From: Contact Centre (CRM) <contact@ribblevalley.gov.uk>
Sent: 10 August 2022 14:23
To: Planning
Subject: Planning Application Comments - 3/2022/0589 FS-Case-443459435

Planning Application Reference No.: 3/2022/0589

Address of Development: 1 Ribble Lane
Chatburn

1 RIBBLE LANE, EXISTING SITE PLAN

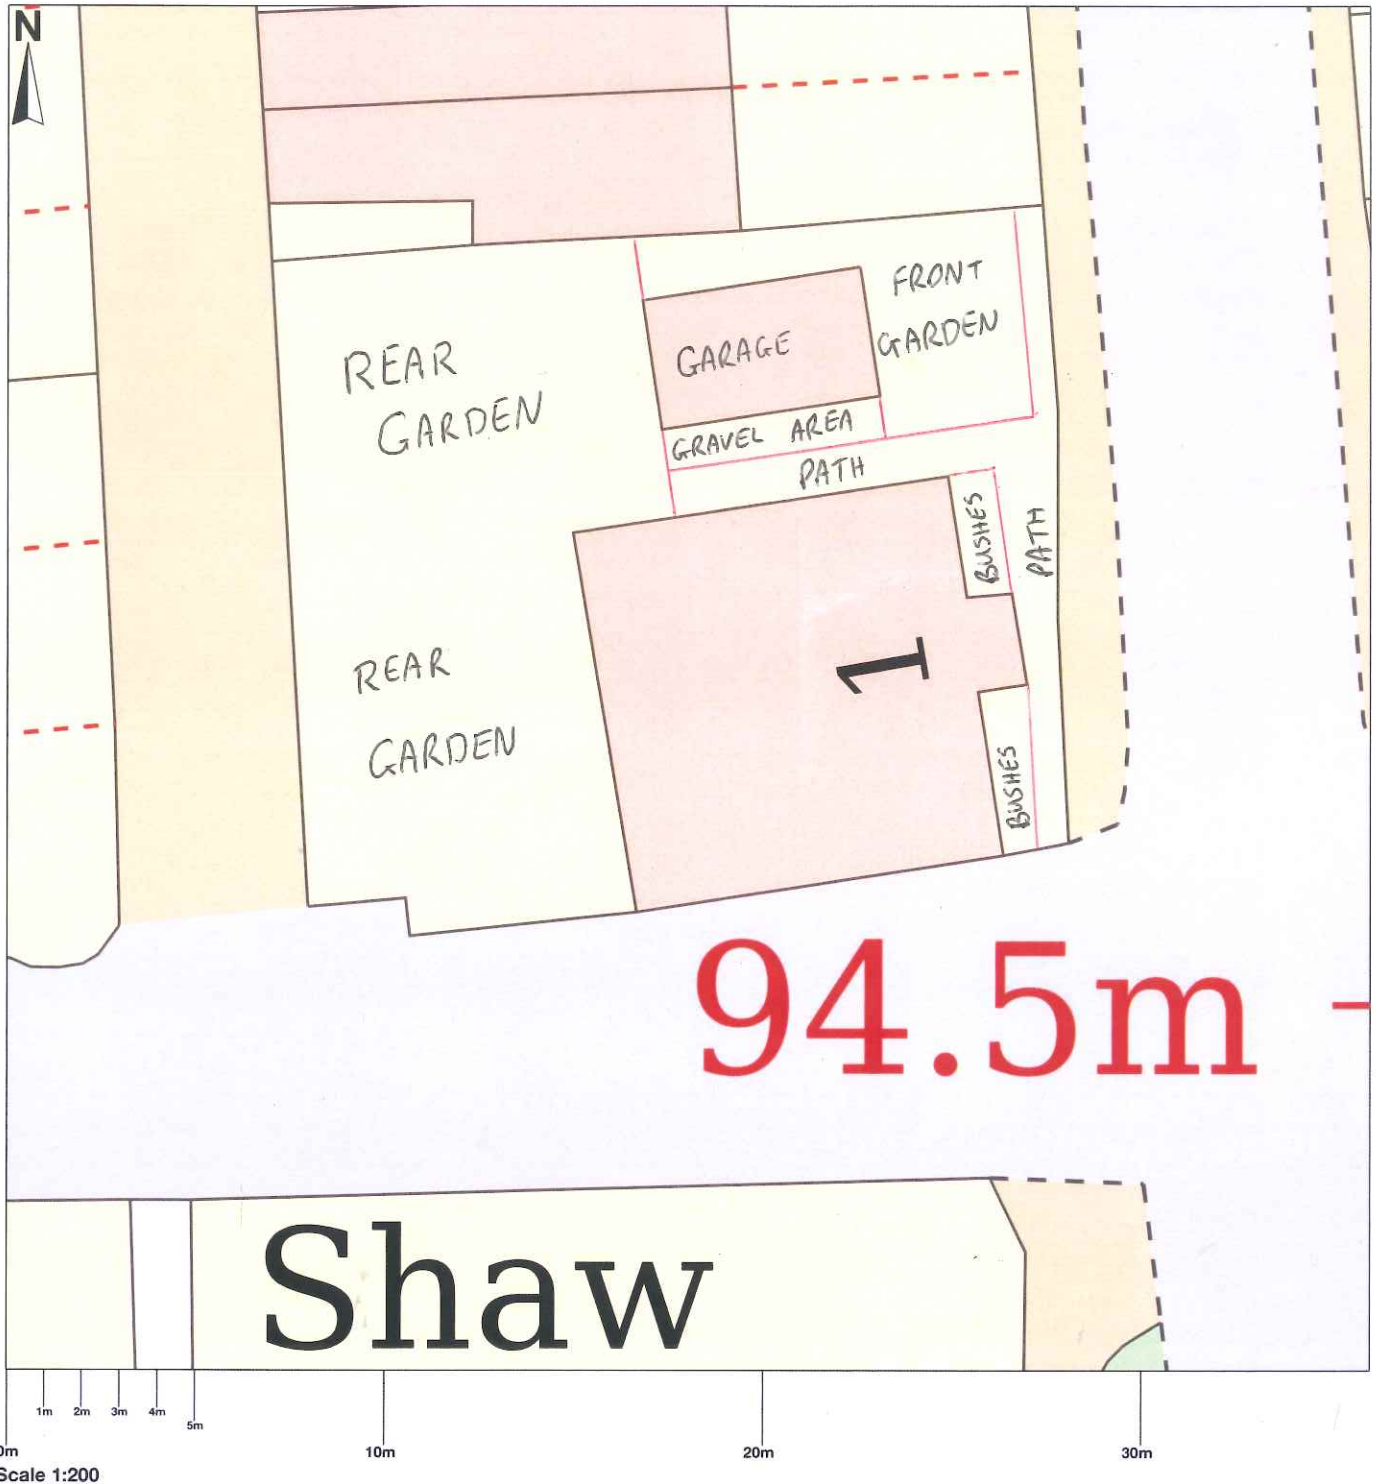
[REDACTED] has been damaged [REDACTED] passing vehicles in the [REDACTED]. The applicant has also been somewhat guarded with his site map, which indicates that the rear of his property is garden when it is in fact used as parking area and has access to his garage. With ample room for two or more vehicles. The photographs indicate that no vehicles were parked opposite the proposed driveway that is not the usual occurrence with vehicles normally parked there by residents and people using the local amenities. The overriding objection is that of safety and I reiterate the need for a site visit.

Proposal: Application for a dropped kerb to the front of Bank House, 1, Ribble Lane, Chatburn. To be used for access to a double driveway.

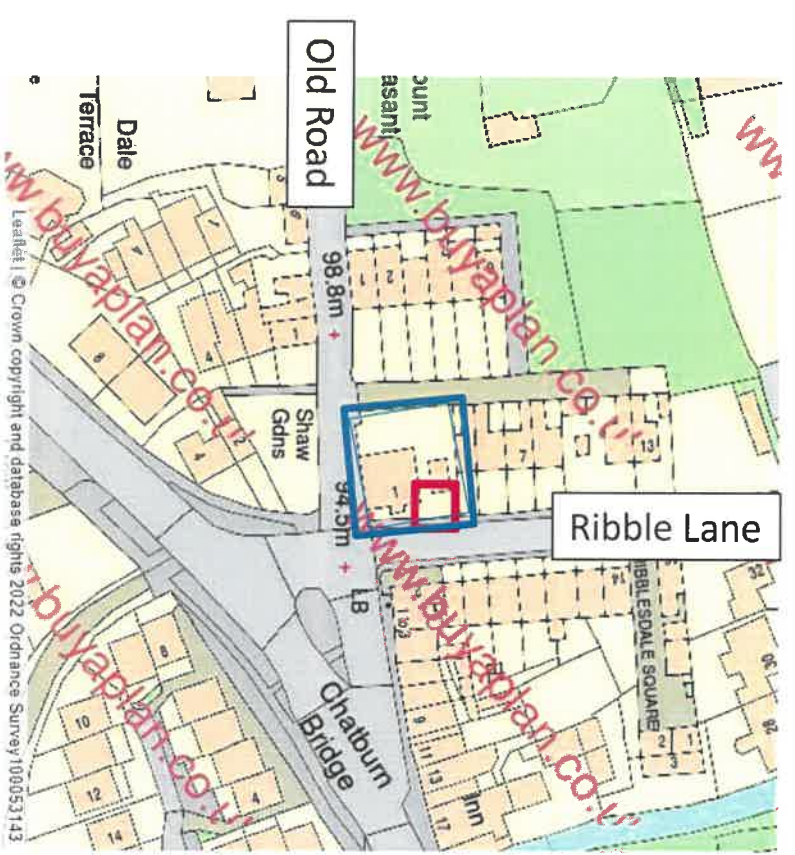
The main concern that I have is around safety – Ribble Lane is a main road used by surrounding villages including a high proportion of school buses and wagons. Reversing onto/off a driveway is an accident waiting to happen on a busy road, especially when there are always cars parked directly opposite on the main road (see pictures attached). If a convex mirror is required, this shows that it is a safety concern.

The application states that there is a small alleyway adjacent to where the proposed driveway would go, but this is not even the width of one car and almost always has a vehicle parked in front of it (see pictures attached).

See pictures attached taken on different days to show that cars park directly opposite when the proposed driveway is. It is very very rare for there to be no cars parked there. The owners must have had to wait a long time to get the picture shown in the planning application showing no cars parked there.

The request to move the bus stop further down Ribble Lane seems drastic. It is not clear on the application where exactly this will be but the pavement is much narrower and a further bottle neck not much further down the street so this would probably be a dangerous place to move it to. The bus stop is still used too. Has a visit been done by LCC Highways Department to check this?
